Rezoning Transportation Analysis
Petition Number: Insert Zoning Petition #2021-066
General Location Identifier: 14903227

Date	Description
05-27-2021	First Review (EL)

Transportation Summary

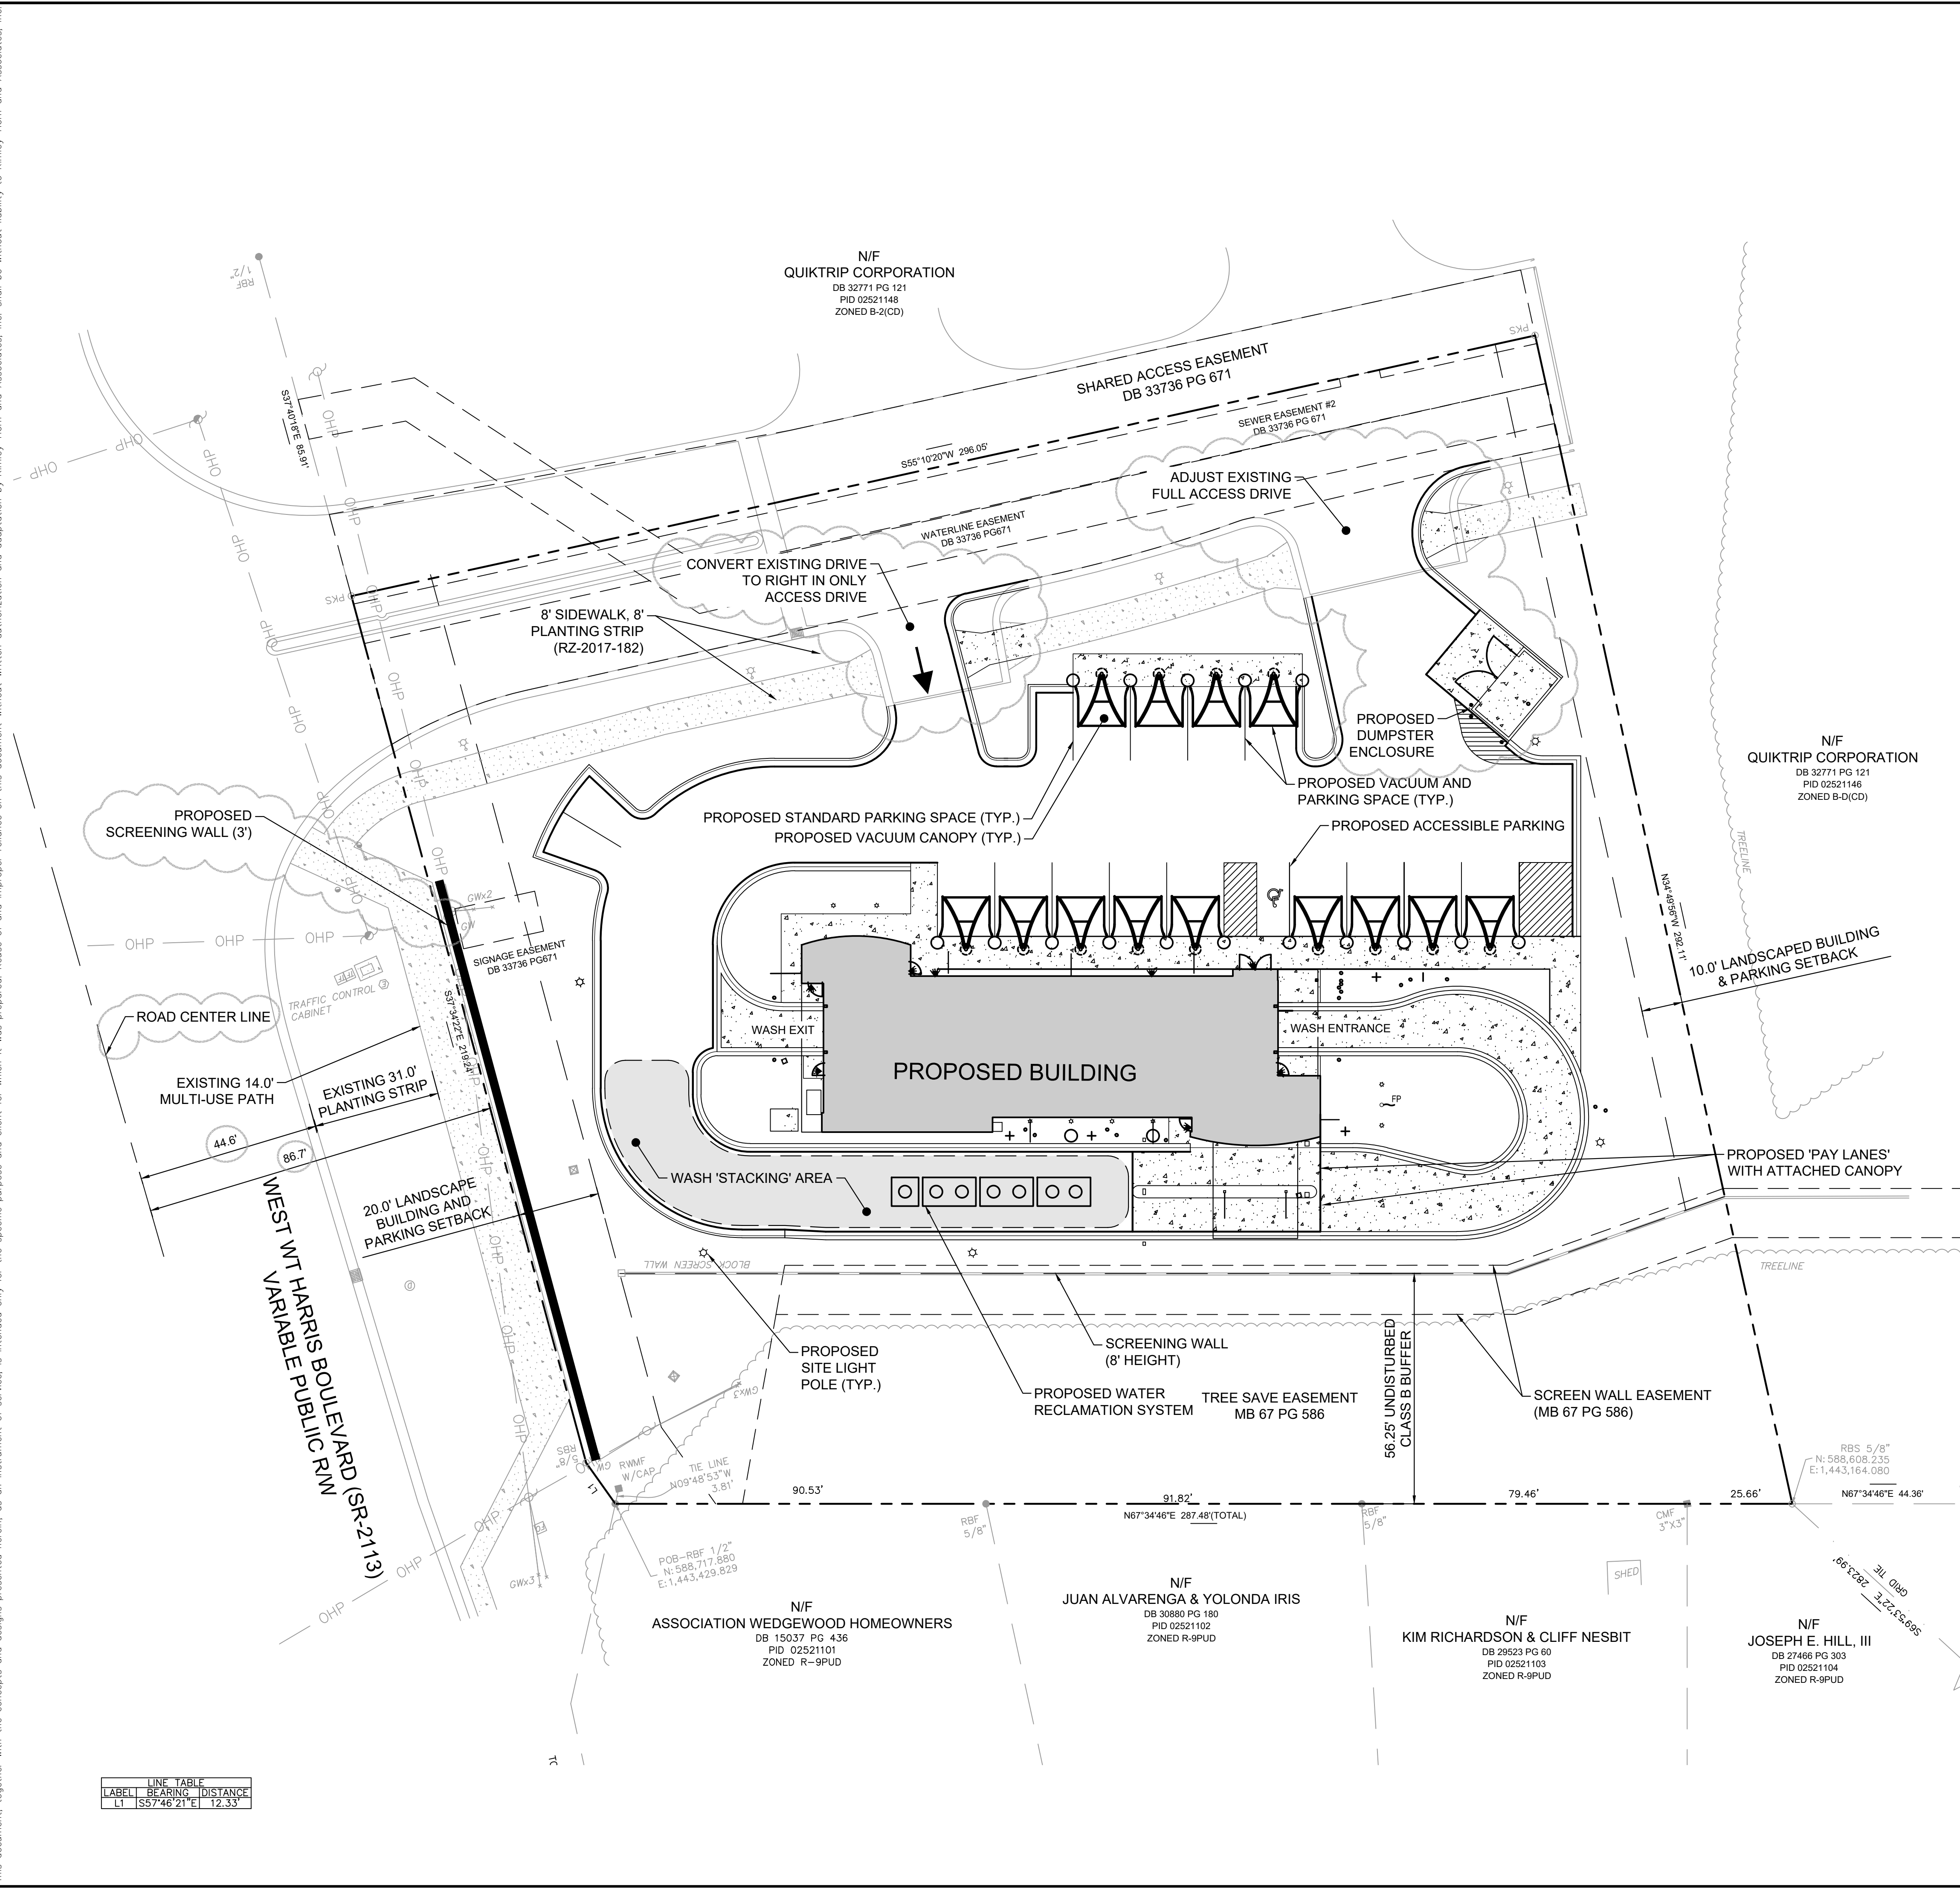
2. Revise site plan and conditional note(s) to commit to dedicate (*if not already provided*) 55-feet of public right-of-way from the WT Harris Boulevard road centerline to accommodate the future WT Harris Boulevard cross section below, which accounts for a future curb line location 33-feet from road centerline to the property frontage, 8-foot planting strip, and a minimum 12-foot wide multi-use path. The site plan shall label and dimension the right-of-way from the road centerline.

3. Revise the site plan and conditional note (**Section 3. Access and Transportation (f)**) to modify the proposed access management per the options provided below.

4. Revise the site plan and conditional note (**Section 5. Streetscape, Setbacks, Buffers and Screening (a)**) to clarify the difference on the site plan and conditional note, related to existing vs. proposed references to a multi-use path. Please clarify whether an existing multi-use path remain, or if a multi-use path is proposed.
